CITY OF ALBUQUERQUE

Re: State Employees Credit Union
3521 Montgomery Blvd. NE
30-Day Temporary Certificate of Occupancy- Transportation Development
Engineer's Stamp dated 10-2-16 (F16D001)
Certification dated 5-23-17

① Site Plan
1" = 30'-0"

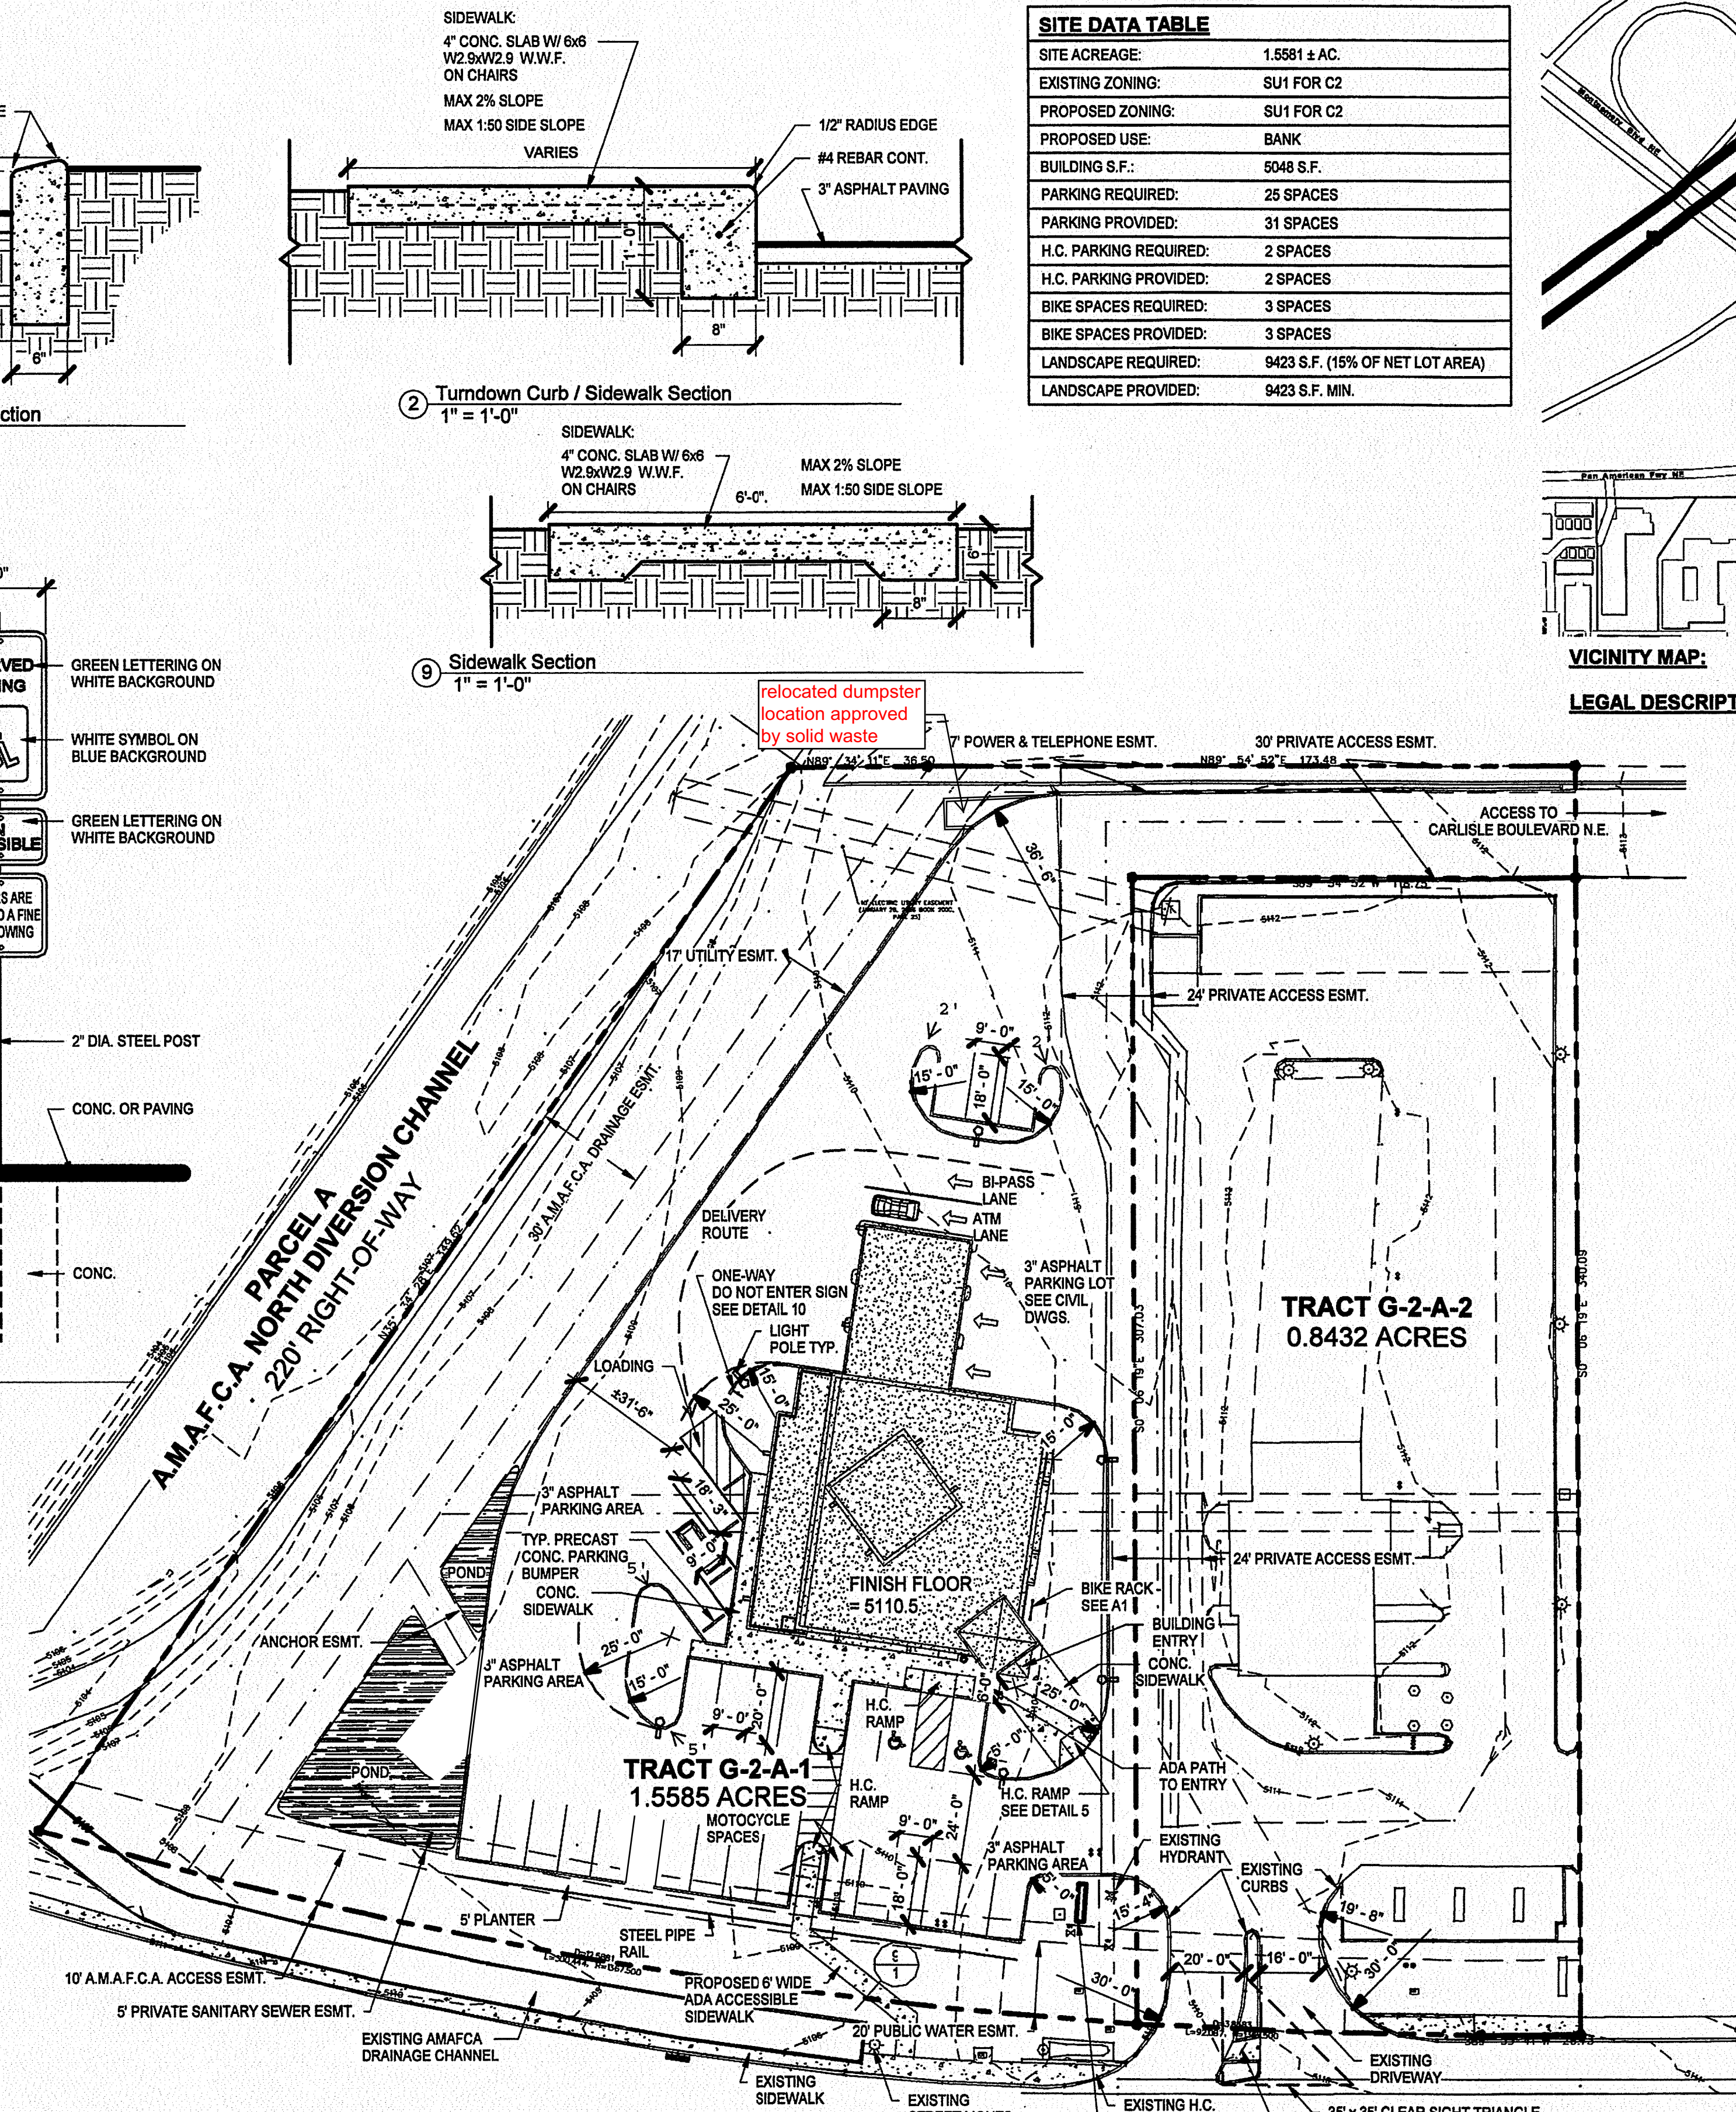
1. Place the "ONE WAY/ DO NOT ENTER" sign where the site plan indicates.
2. The "NO EXIT" sign located on the westside of the building needs to be correctly facing south bound traffic on site.
